# CORRECT PLANNING AND CONSULTATION FOR MAYFIELD GROUP ( CPCFM )

Mayfield West Recycling Facility Extension (SSD 7698)

Comment on the Environmental Impact Statement

Figure A3.6 Predicted Incremental Annual Average Dust Deposition Levels (g/m²/month)

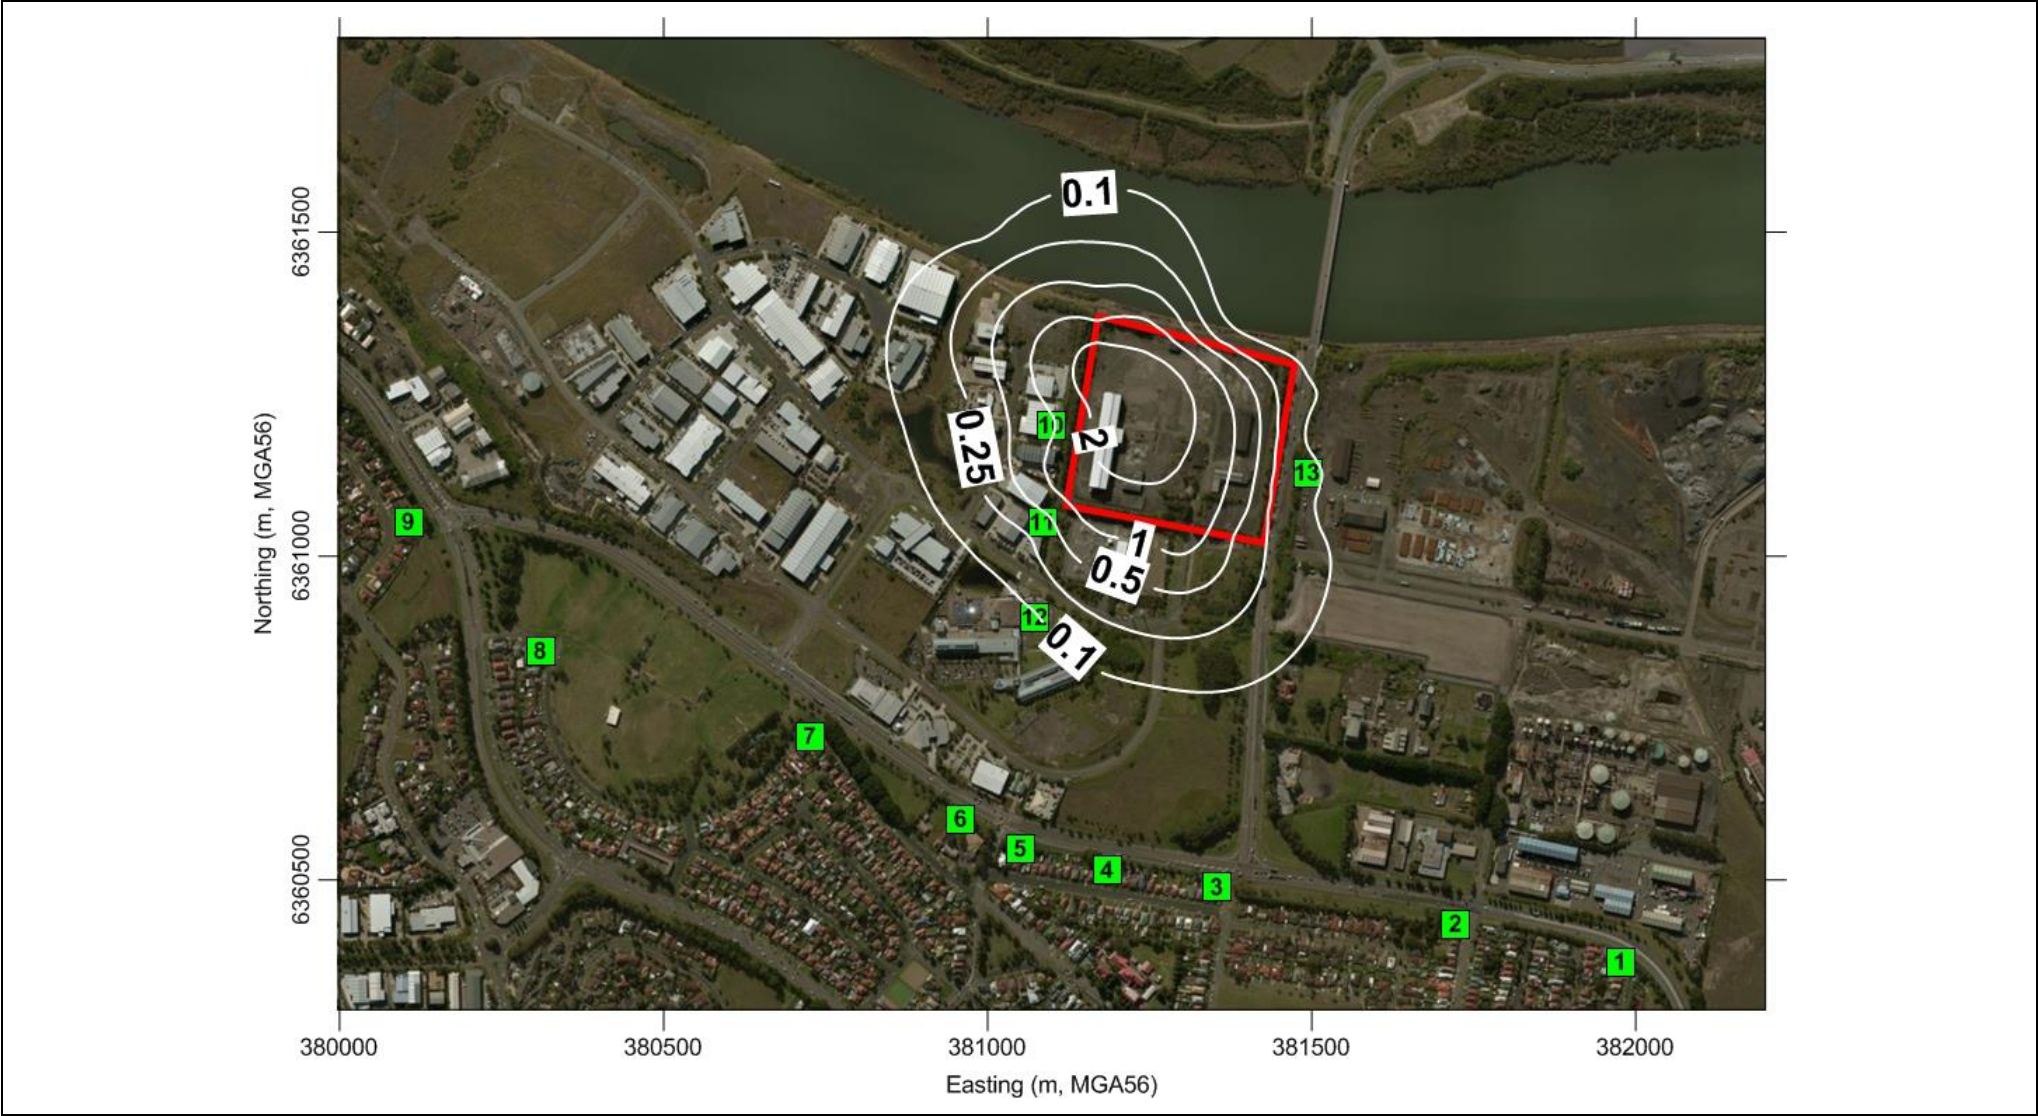
CPCFM, and the community of Mayfield, are very concerned with the increase in dust potential from the very open site, the increased stockpile surface area and open shed. The dust assessment from the site would appear to be inadequate and not of a sound scientific basis. We believe results are understated.
